Our Ref: LU/323/17/PL

**Town & Country Planning Act 1990 (as amended)
Town and Country Planning (Development Management Procedure) (England) Order 2015
Application for Planning Permission**

Development Change of use of former United Services Club (Sui Generis) to 10 No. flats (C3 Dwelling House) with associated landscaping, parking, bins and recycling storage.

Location United Services Maltravers Road Littlehampton

First Floor Plan

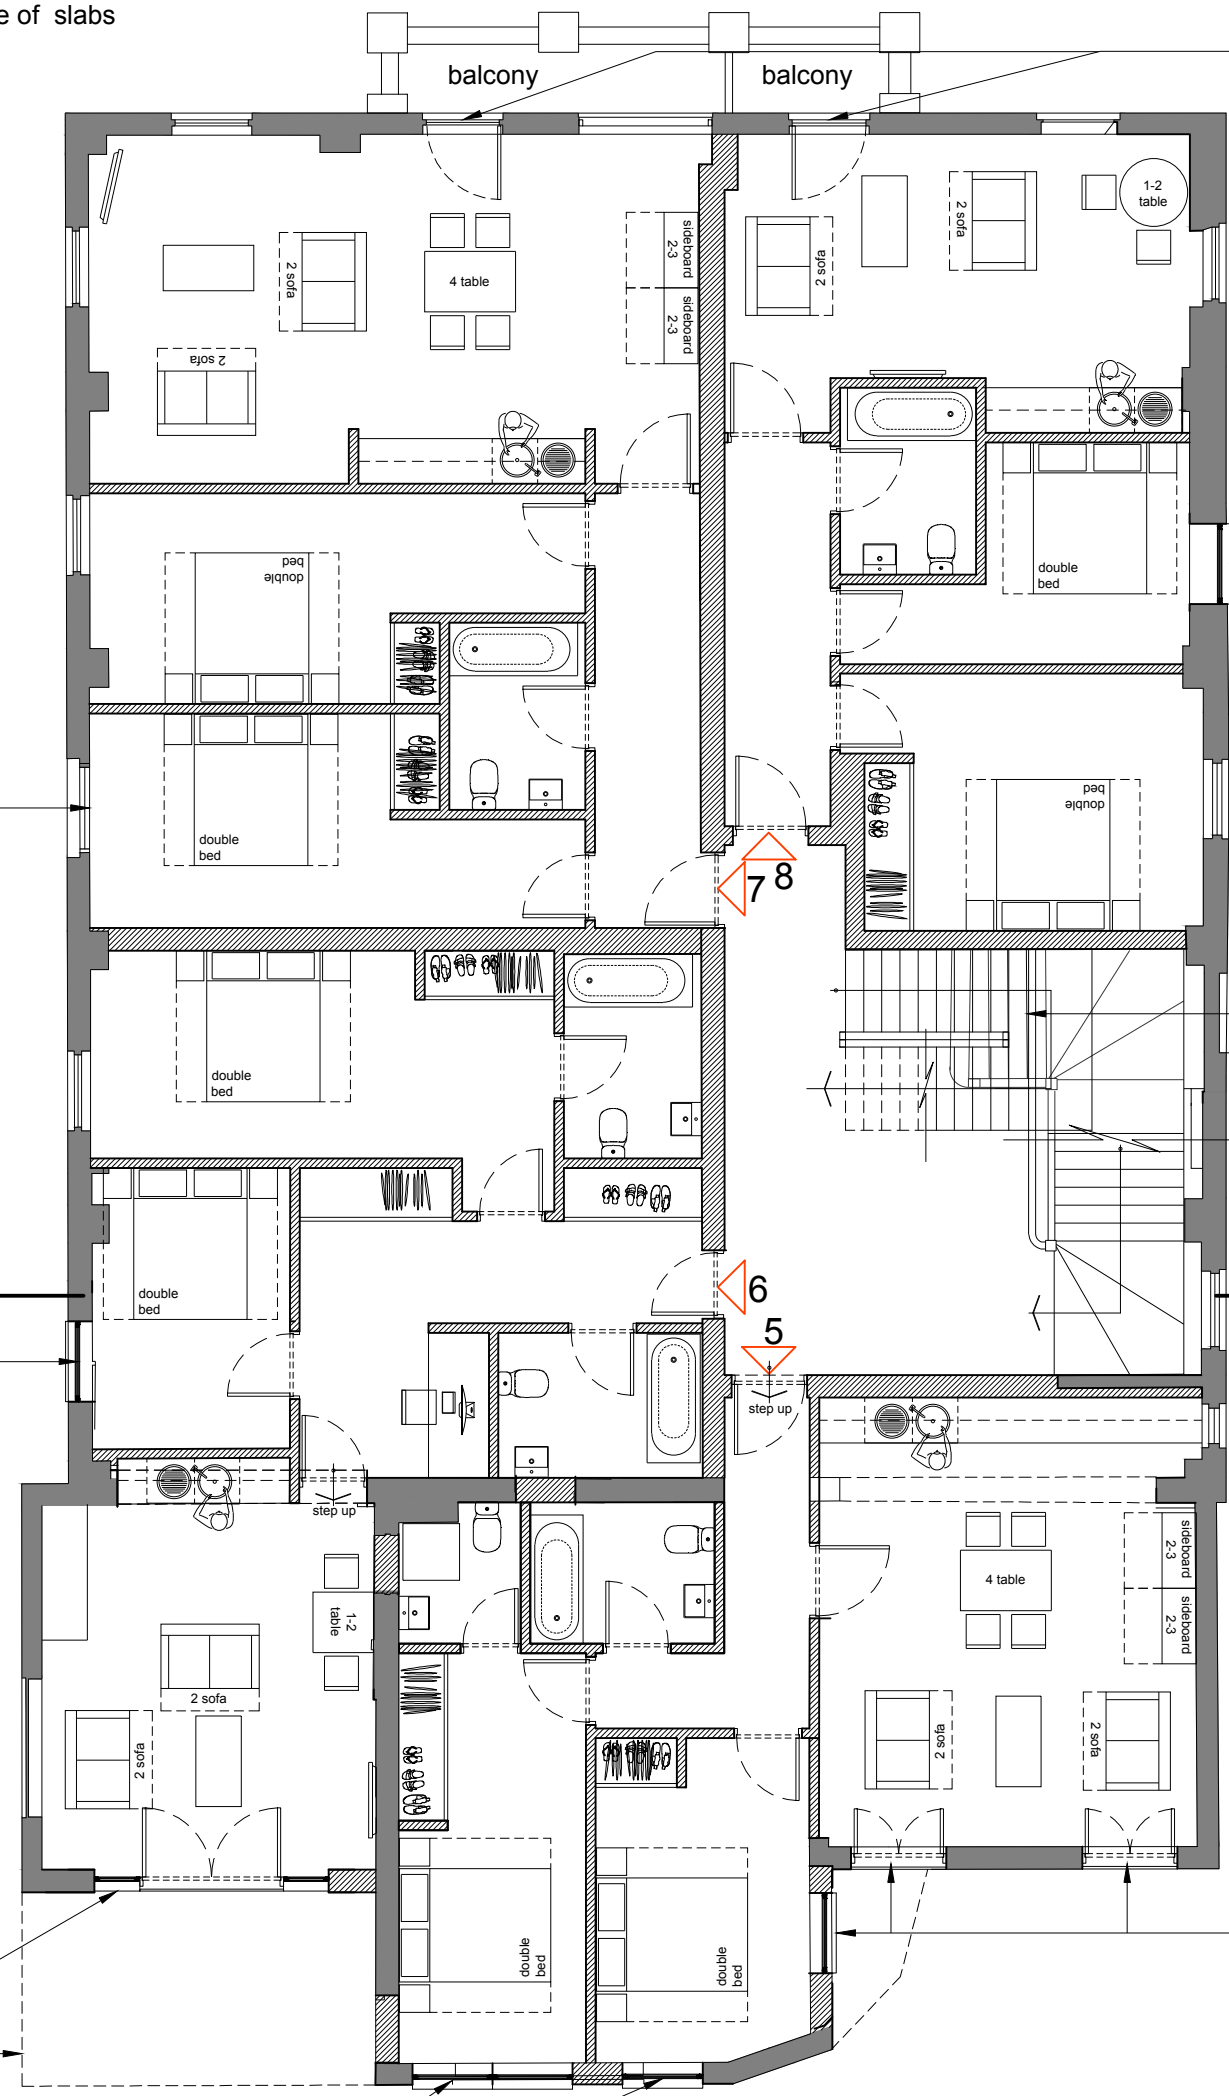
The proposed first floor plan and West elevation do not accord. Please amend accordingly.

Loft Level Plan

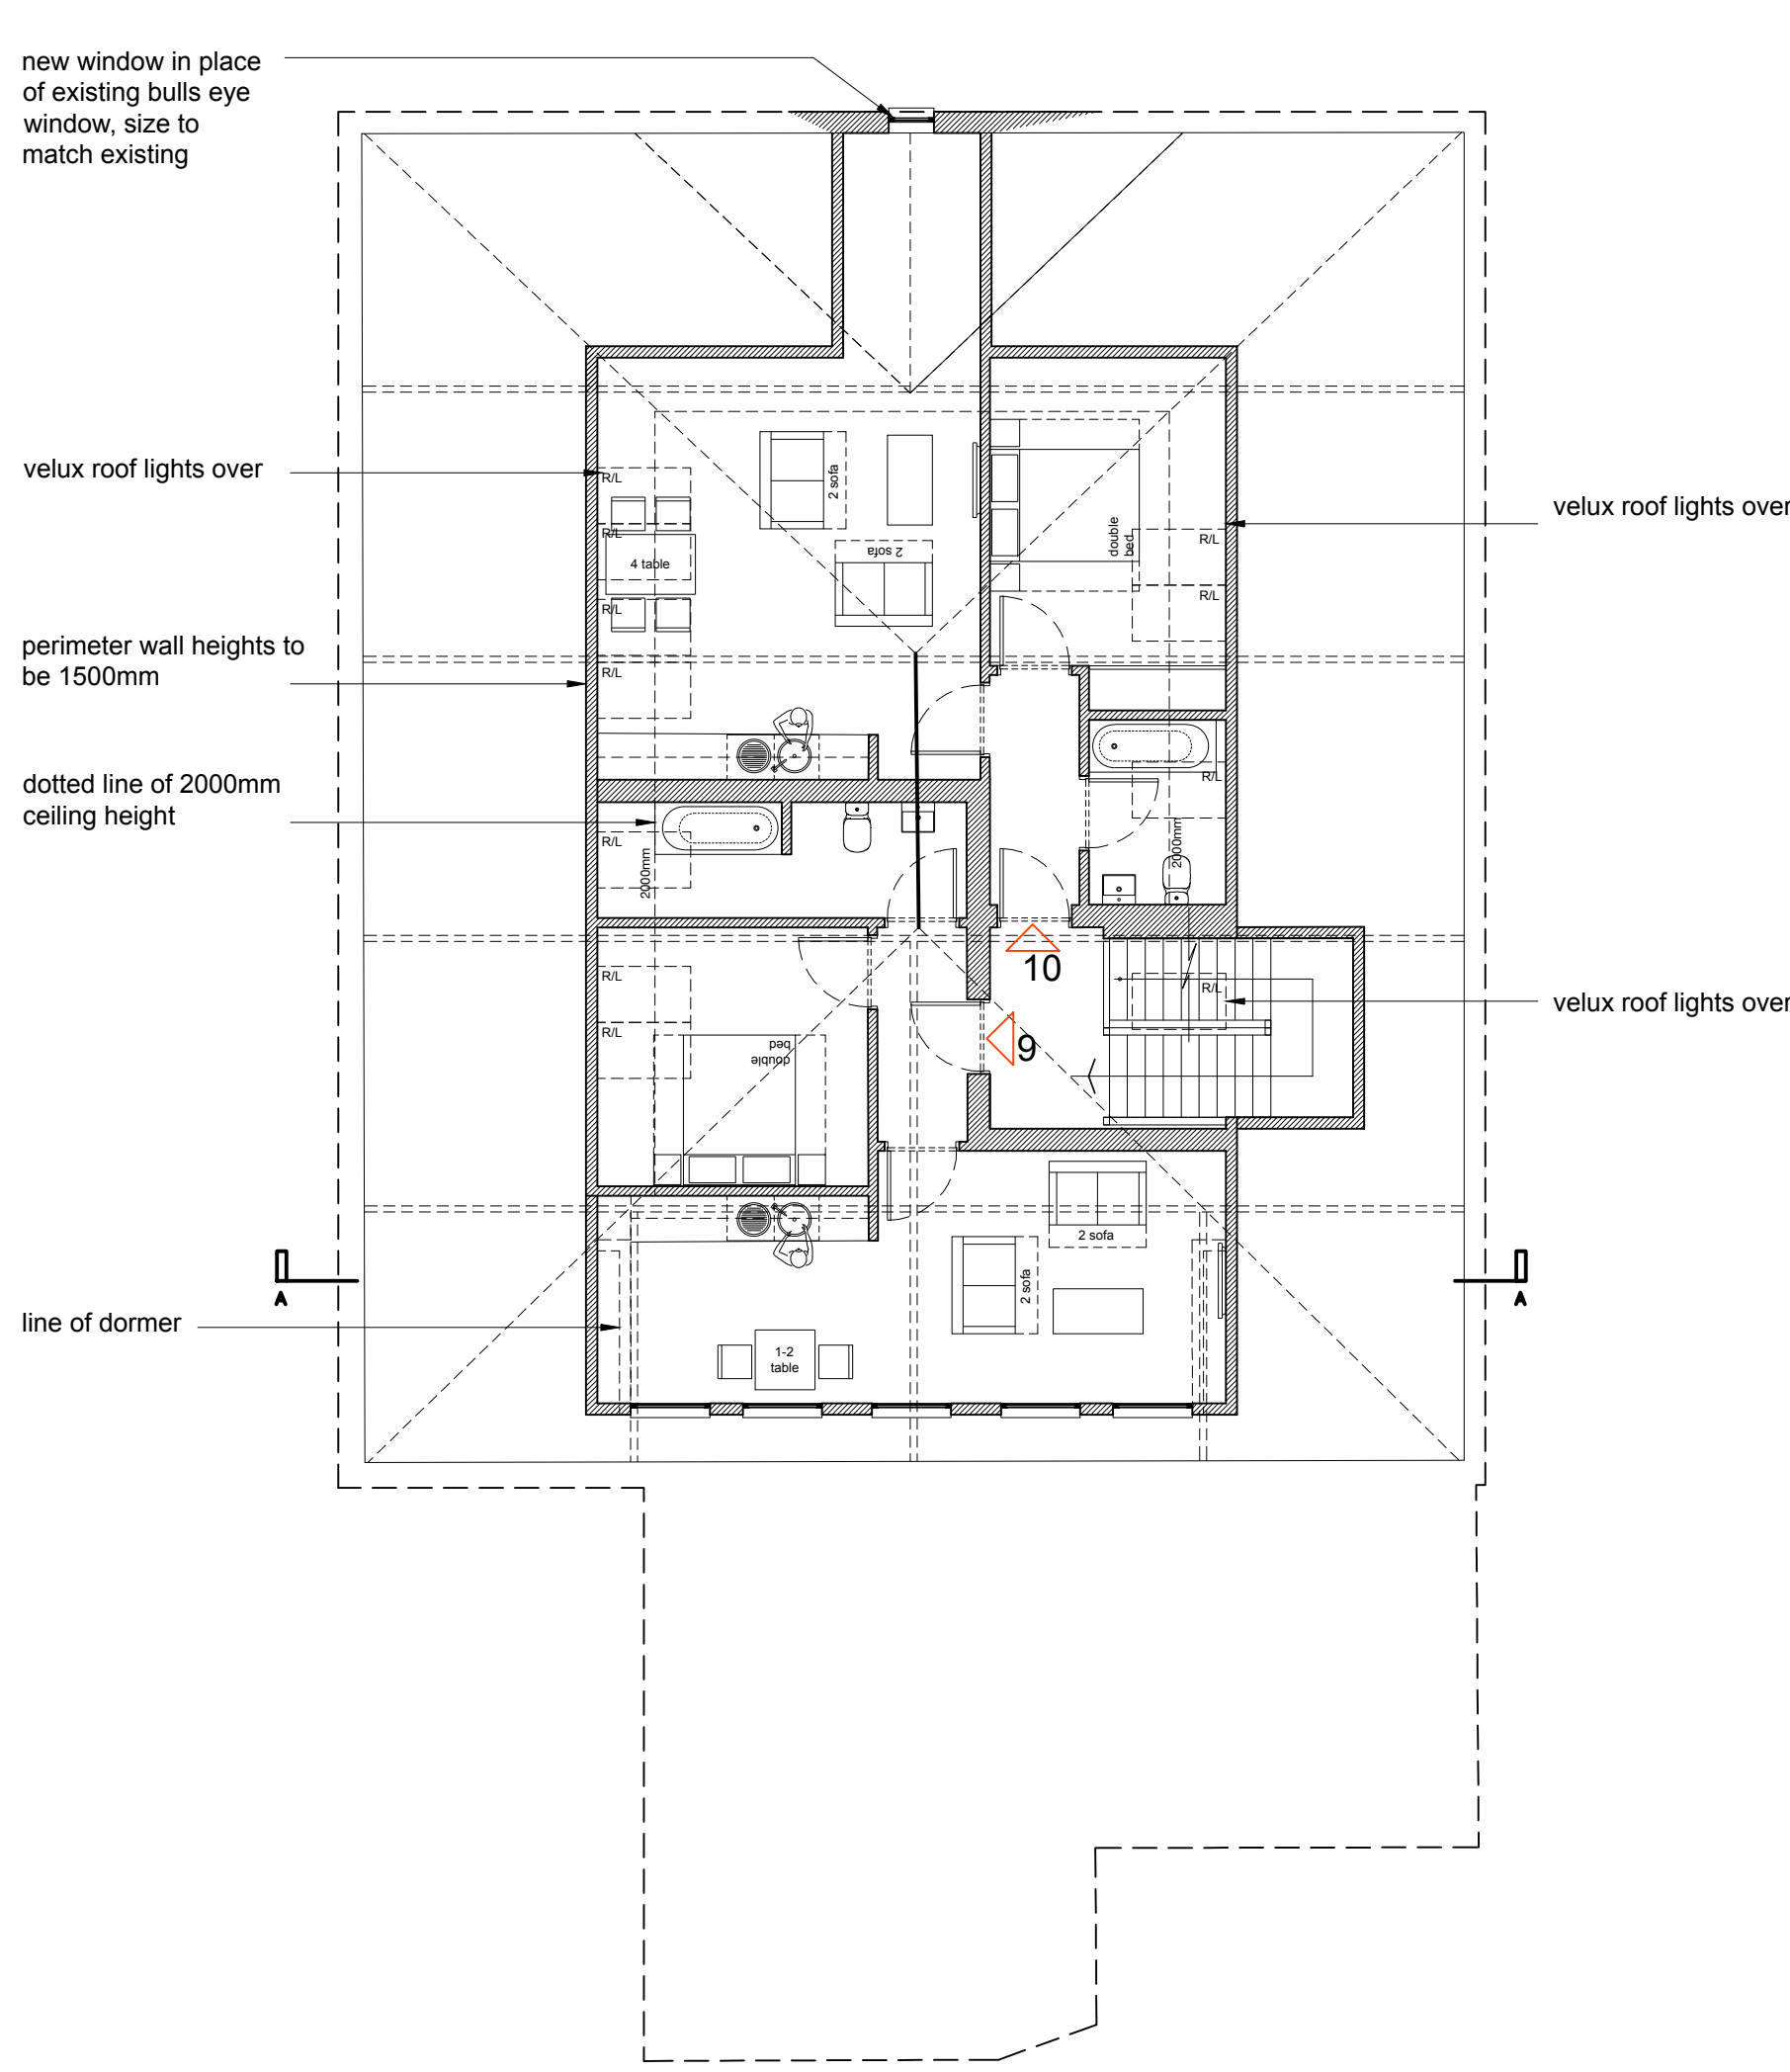
The roof lights on the proposed East elevation and proposed roof plan do not accord. Please amend accordingly.
